The Planning Inspectorate

**Application by National Highways for an Order Granting Development Consent for
the A66 Trans-Pennine Dualling Project**

Procedural Decision made under Section 89

ANNEX A – Matters Arising from Acceptance

Drawing Title
**Special Category Land Plans
Regulation 5(2)(i)
Sheet 2 of 3**

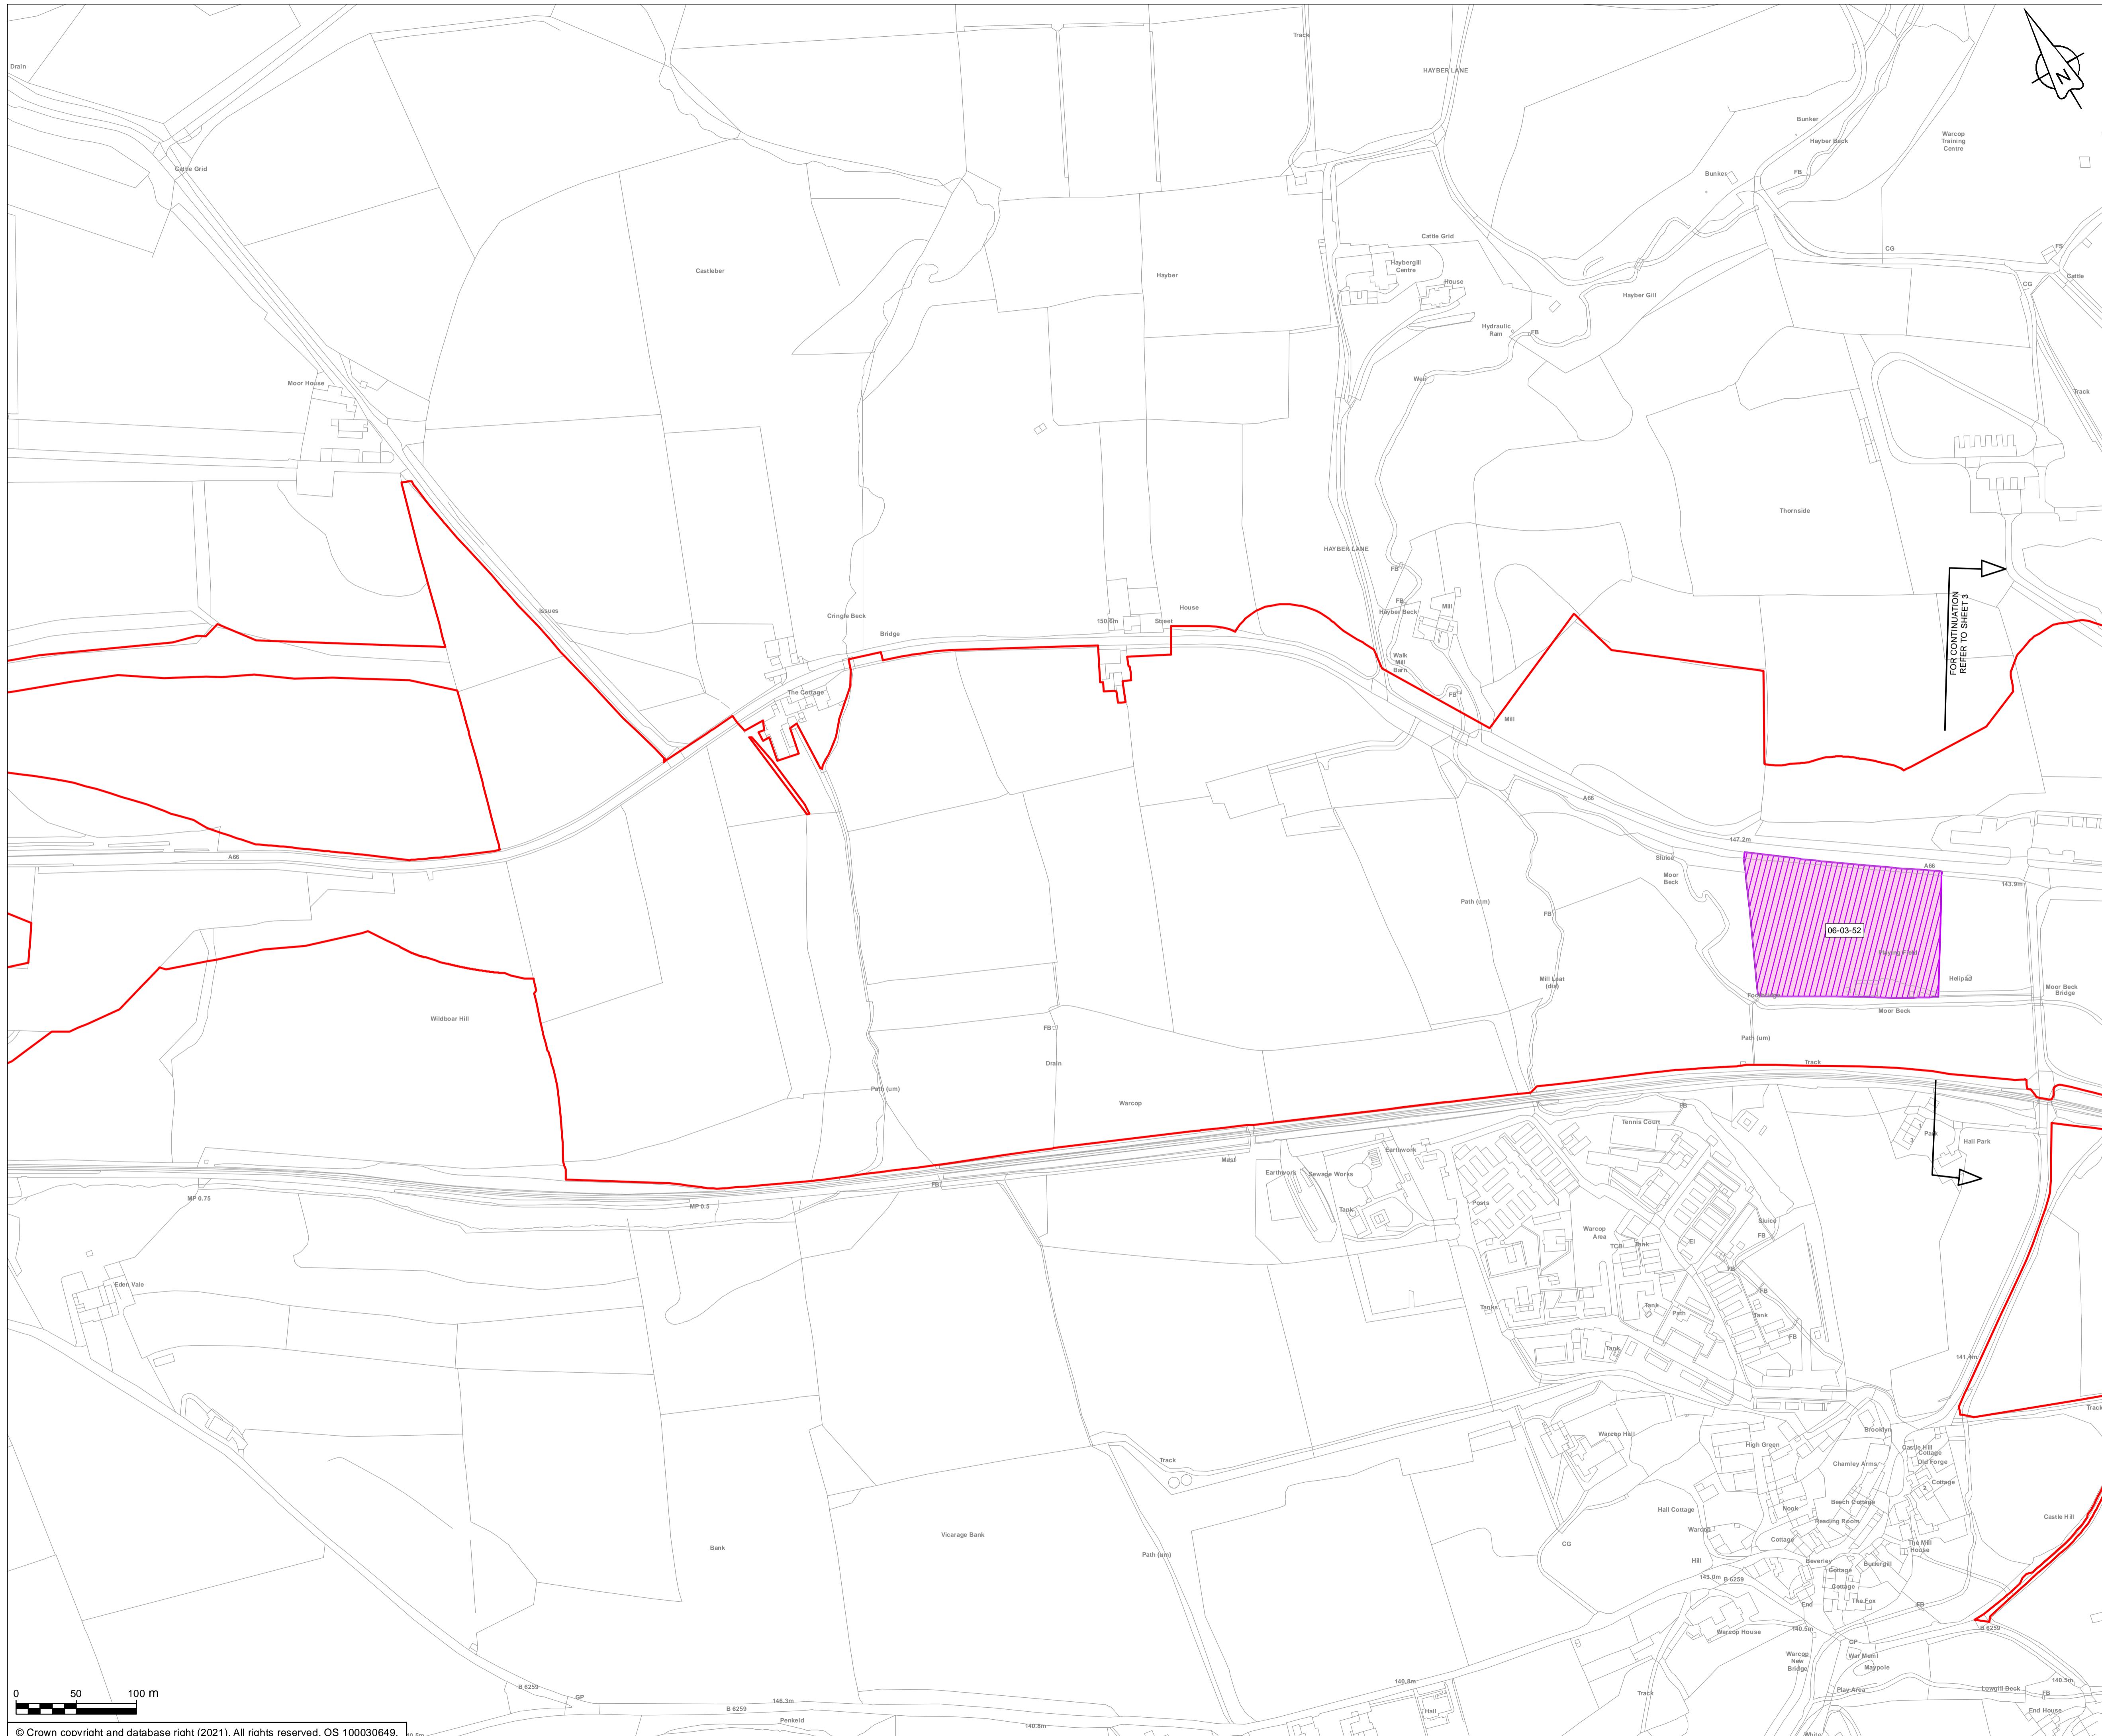
App Document No	Document	Comments
		Para. 7.2.10 and accompanying table – listed Plot 0102-02-54 on the relevant Special Category Land Plan isn't in the SoR table. Please check.
Document 5.7	Book of Reference (BoR)	Applicant is required to check that all plots are contained within the Book of Reference. The search functionality did not consistently identify the plots.
Document 5.13	Land Plans	<p><u>Scheme 0102: M6 Junction 40 to Kemplay Bank</u></p> <p><i>Sheet 1:</i></p> <p>Plot 0102-01-25 parcel of land to the NW of 0102-01-25 looks to be separate with no label.</p> <p><i>Sheet 2:</i></p> <p>Plot 0102-02-01 not immediately clear that parcel of land to the West is included.</p> <p>Plot 0102-02-35 land to SW is not clear if it forms part of Plot 0102-02-35 or is a separate plot.</p> <p>Inset 2a is missing plot labels.</p> <p><u>Scheme 0405: Temple Sowerby to Appleby</u></p> <p><i>Sheet 1:</i></p> <p>Plot 0405-01-51 boundaries are unclear.</p> <p><i>Sheet 3:</i></p> <p>Inset 3F Plot 0405-03-49 is labelled twice, unclear if it's a different plot.</p> <p><i>Sheet 4:</i></p> <p>Plot 0405-04-34 is listed in BoR but does not appear to exist in the Land Plans.</p> <p><i>Sheet 5A:</i></p> <p>Plot 0405-05-09 is marked on Insert 5D but is not contained within the BoR.</p> <p><i>Sheet 7:</i></p> <p>Plot 0405-07-37 – Check whether this extend into Insert 7A and should be marked up as such.</p> <p><u>Scheme 06 Appleby to Brough</u></p> <p><i>Sheet 1:</i></p> <p>Plot 06-01-10 lists plot size as 2435 square metres. This may be incorrect, and the Applicant is asked to check.</p> <p>Plot 06-01-39 is keyed in the land plans as 'Permanent Acquisition of Land – Replacement Land', while the 'replacement land' bit isn't mentioned in the BoR.</p>
